Reference No:	2024/62/92504/W
Site Address:	134, Birkby Hall Road, Birkby, Huddersfield, HD2 2UZ
Description:	Change of use from vehicle repair and sales to vehicular repair, sales and hand car wash with associated works (within a Conservation Area)
Recommending Officer:	Nicole Helliwell

DECISION - REFUSE

Officer Report

Proposal: Change of use from vehicle repair and sales to vehicular repair, sales and hand car wash with associated works (within a Conservation Area).

Drawing Title:  
EXISTING AND PROPOSED PLAN.

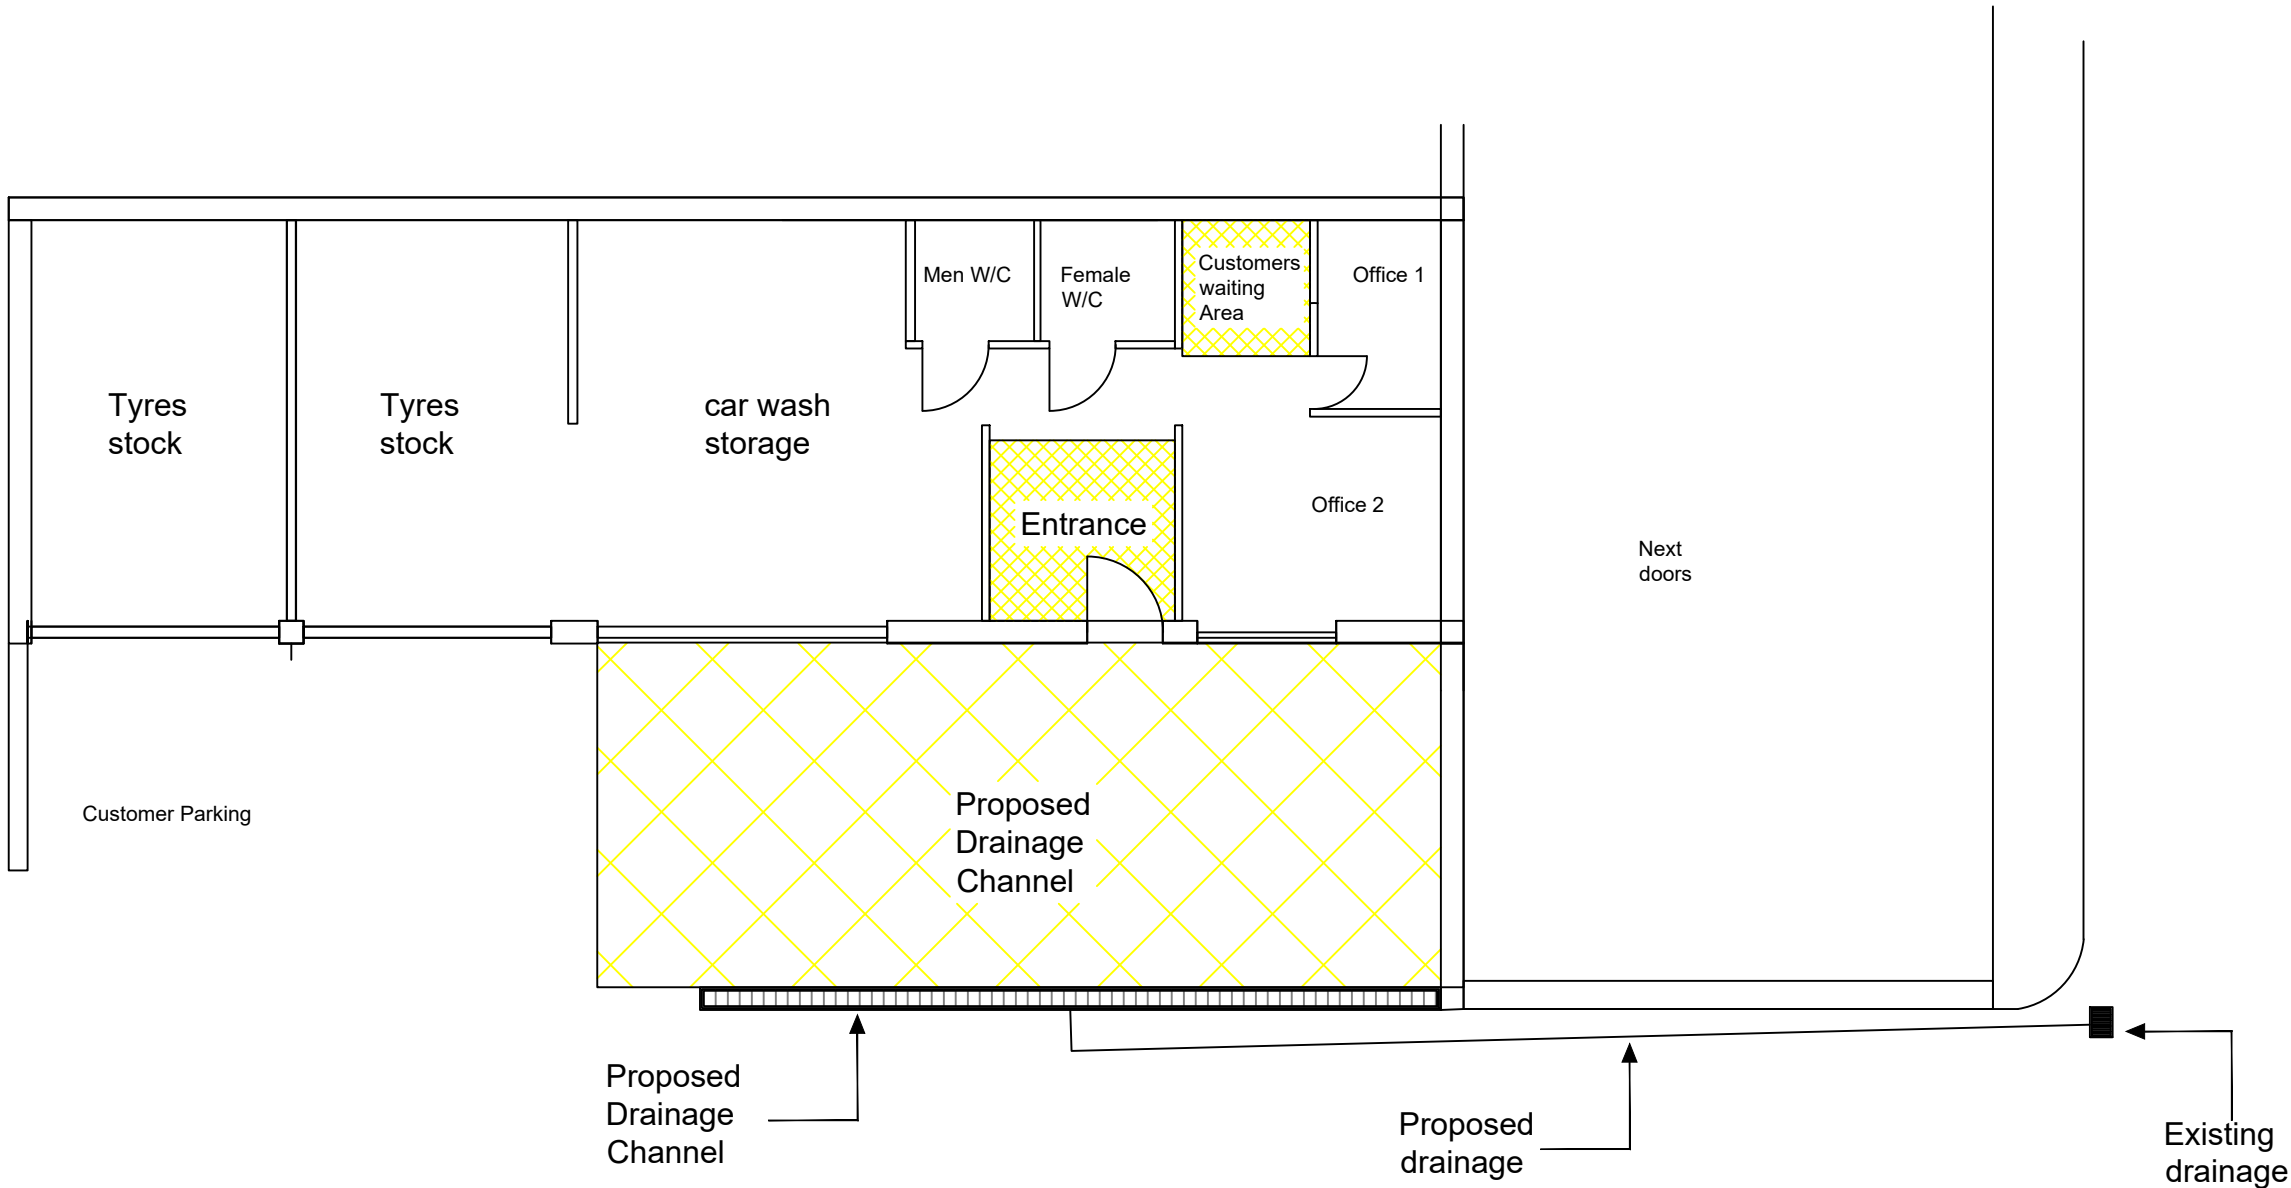
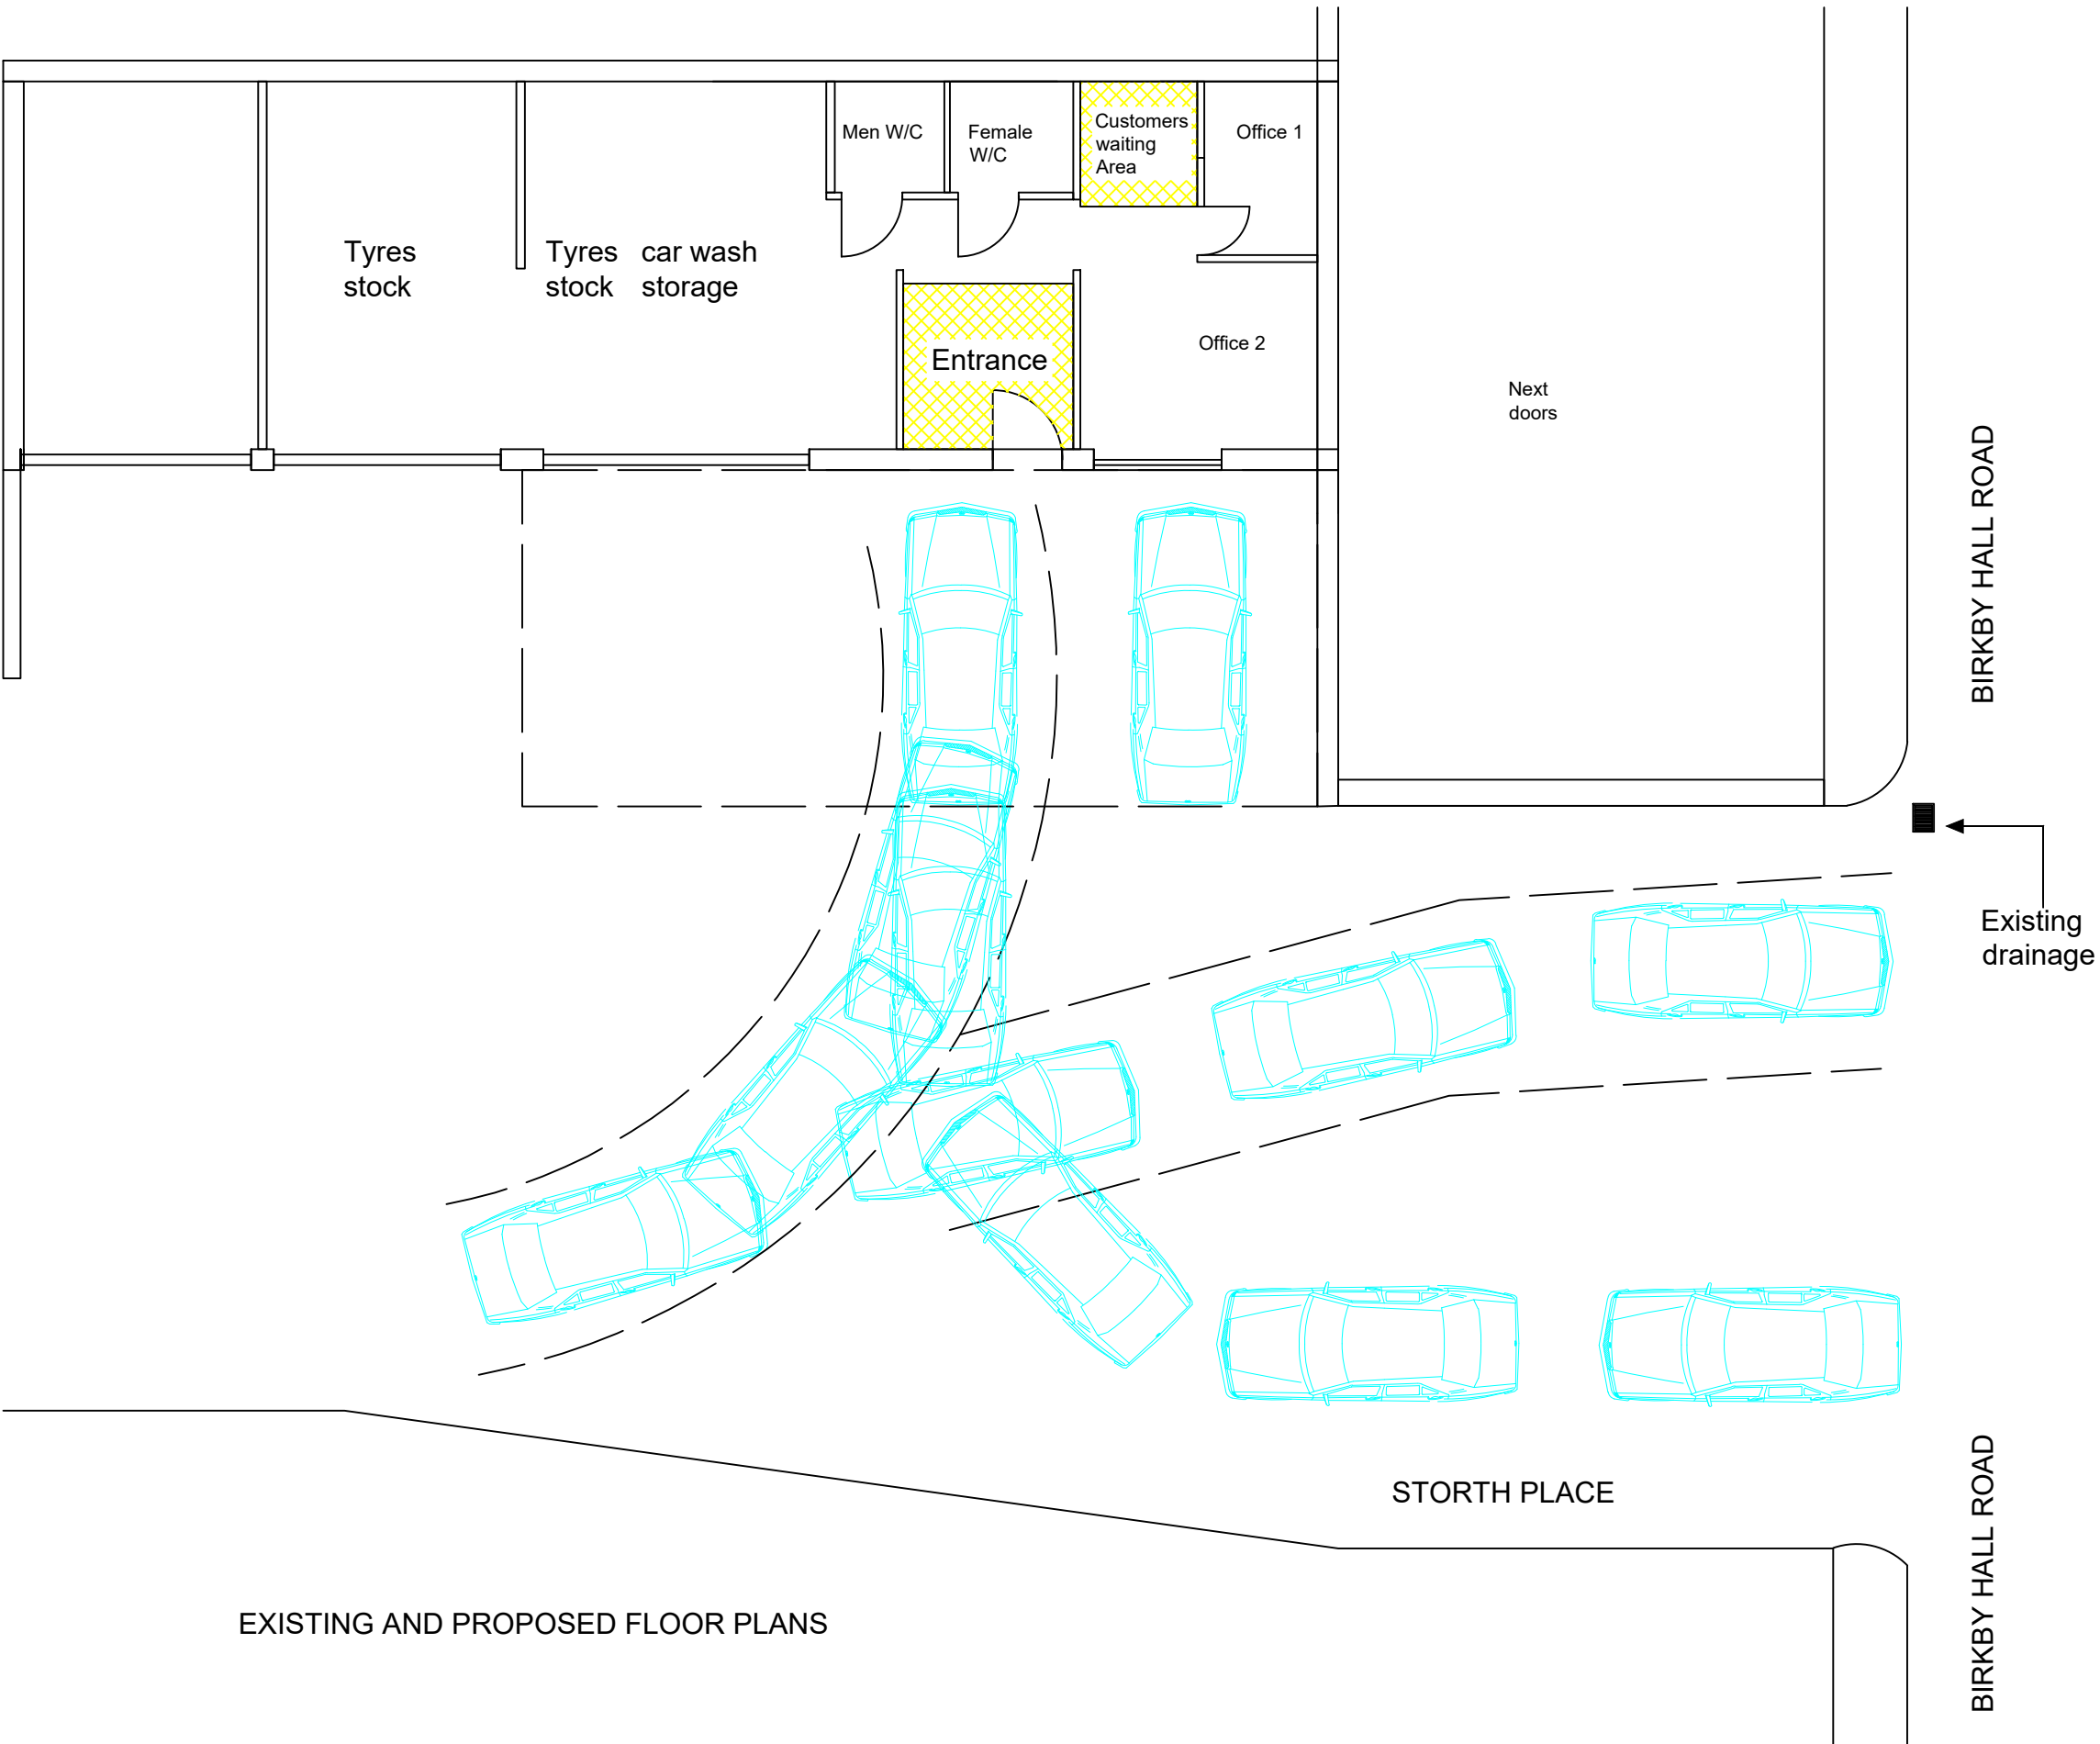
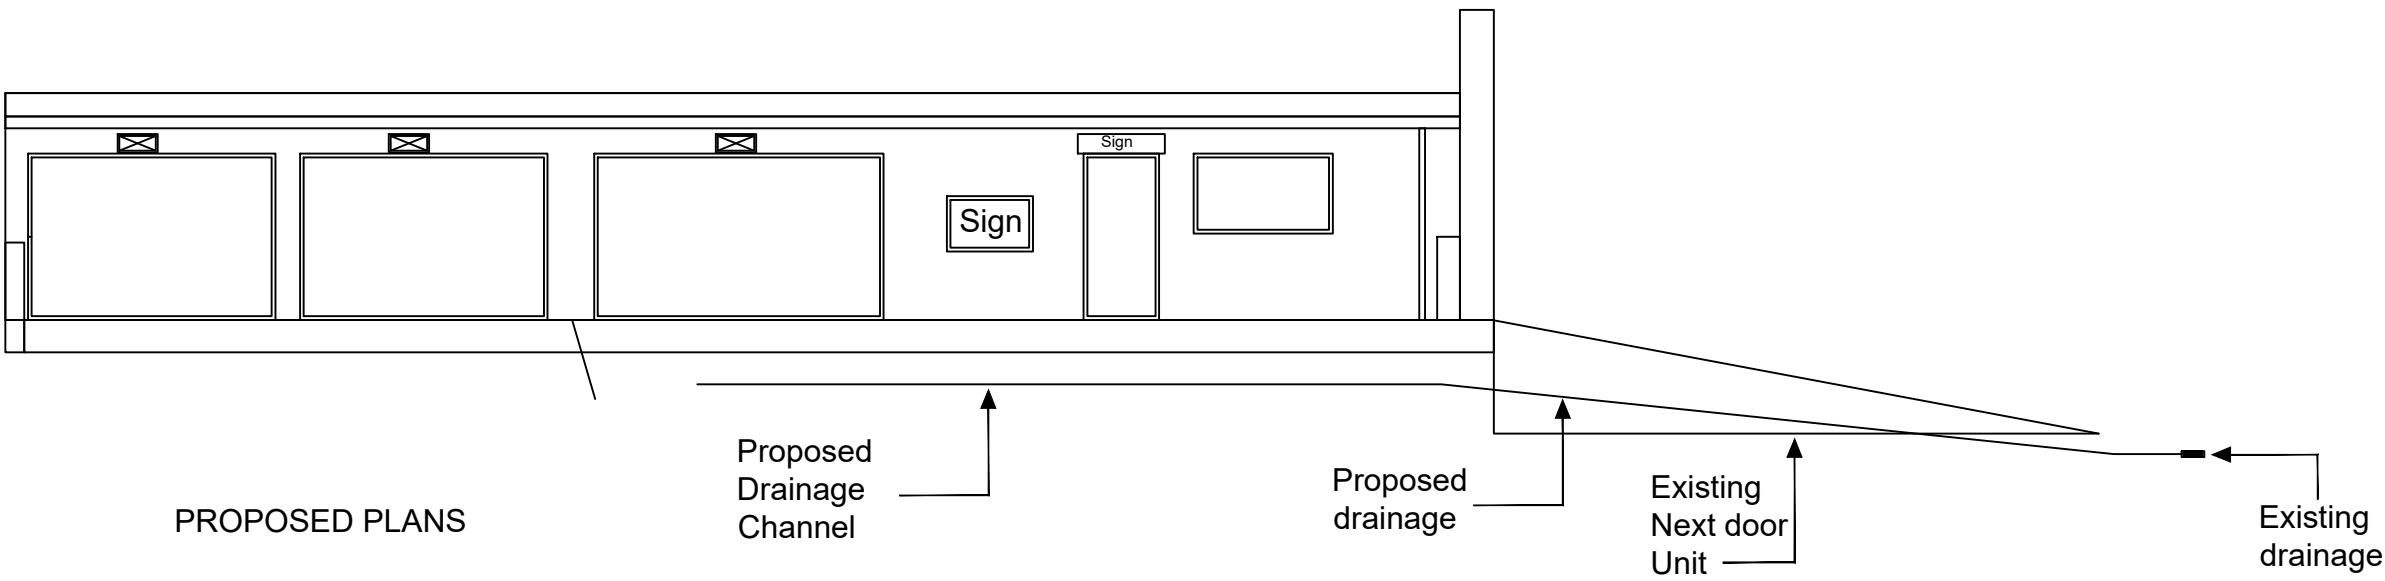
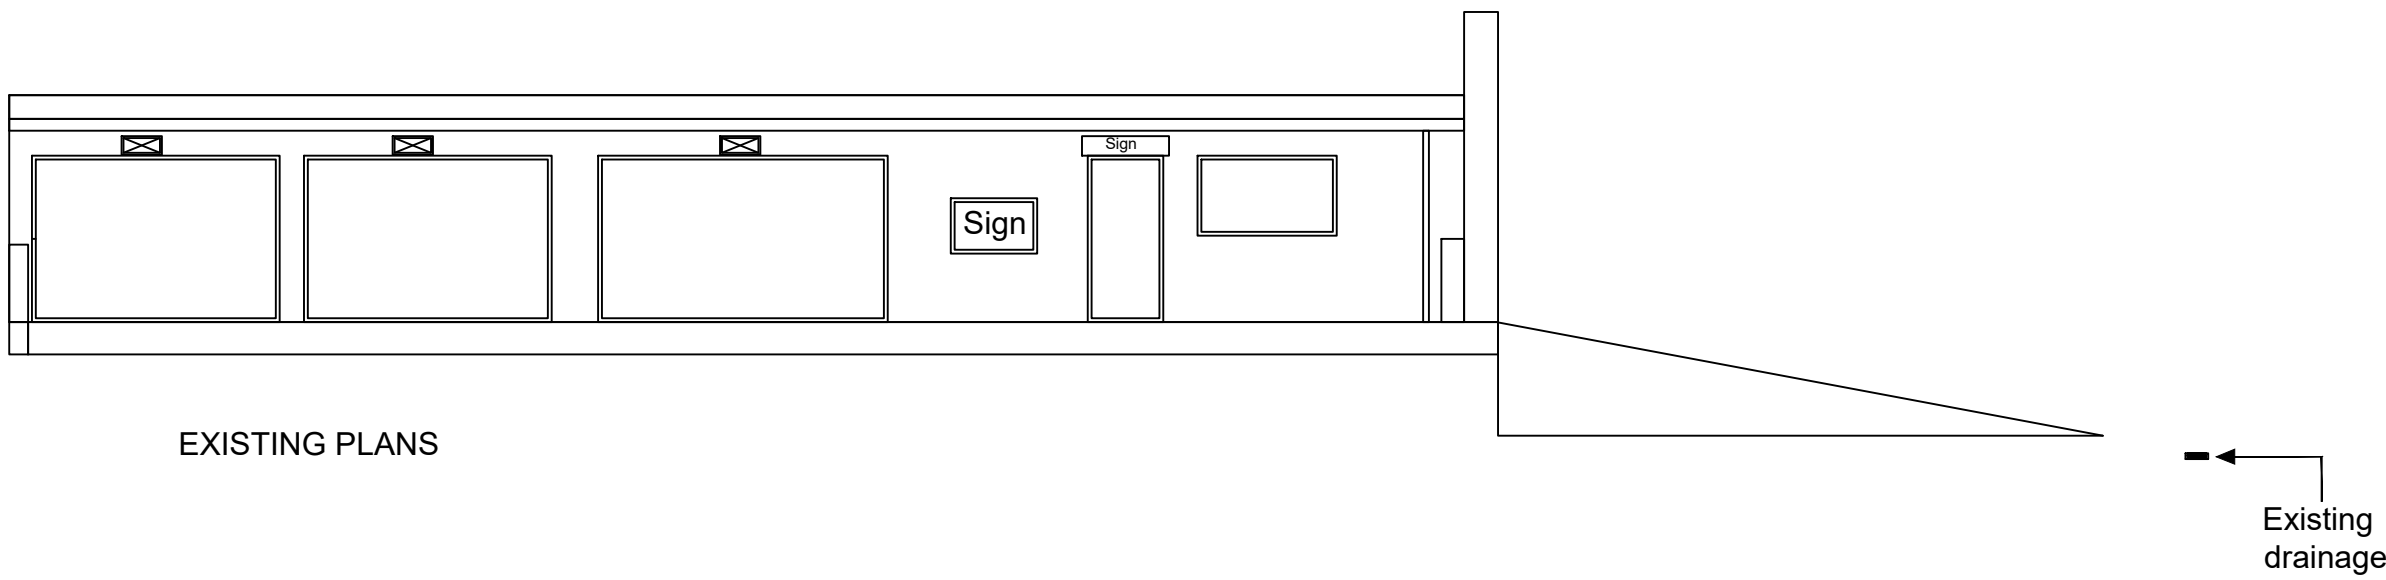
The proposal is for a change of use from vehicle repair and sales to vehicular repair, sales and hand car wash with associated works. The original proposal was for the car wash area to be located on the site forecourt which was considered to be an overdevelopment of the site. However, this proposal has been revised so that the car wash area would be located within the garage and the forecourt would be used for waiting vehicles. The applicant has also stated that an appointment only system will be used which will regulate the number of vehicles on the site at any one time. As a result, the proposals are now considered acceptable to KC Highways Development Management.

- Although on the planning it says there will be a channel for a drain the road is rough terrain which will be washed away with constant use of water.

Amendments were sought during the course of the application. The applicant's agent provided a revised block plan to address the concerns relating to highway safety. The revised plan was considered acceptable.

Response: *Yorkshire Water were formally consulted on the proposed scheme and have recommended a condition should the application be approved.*
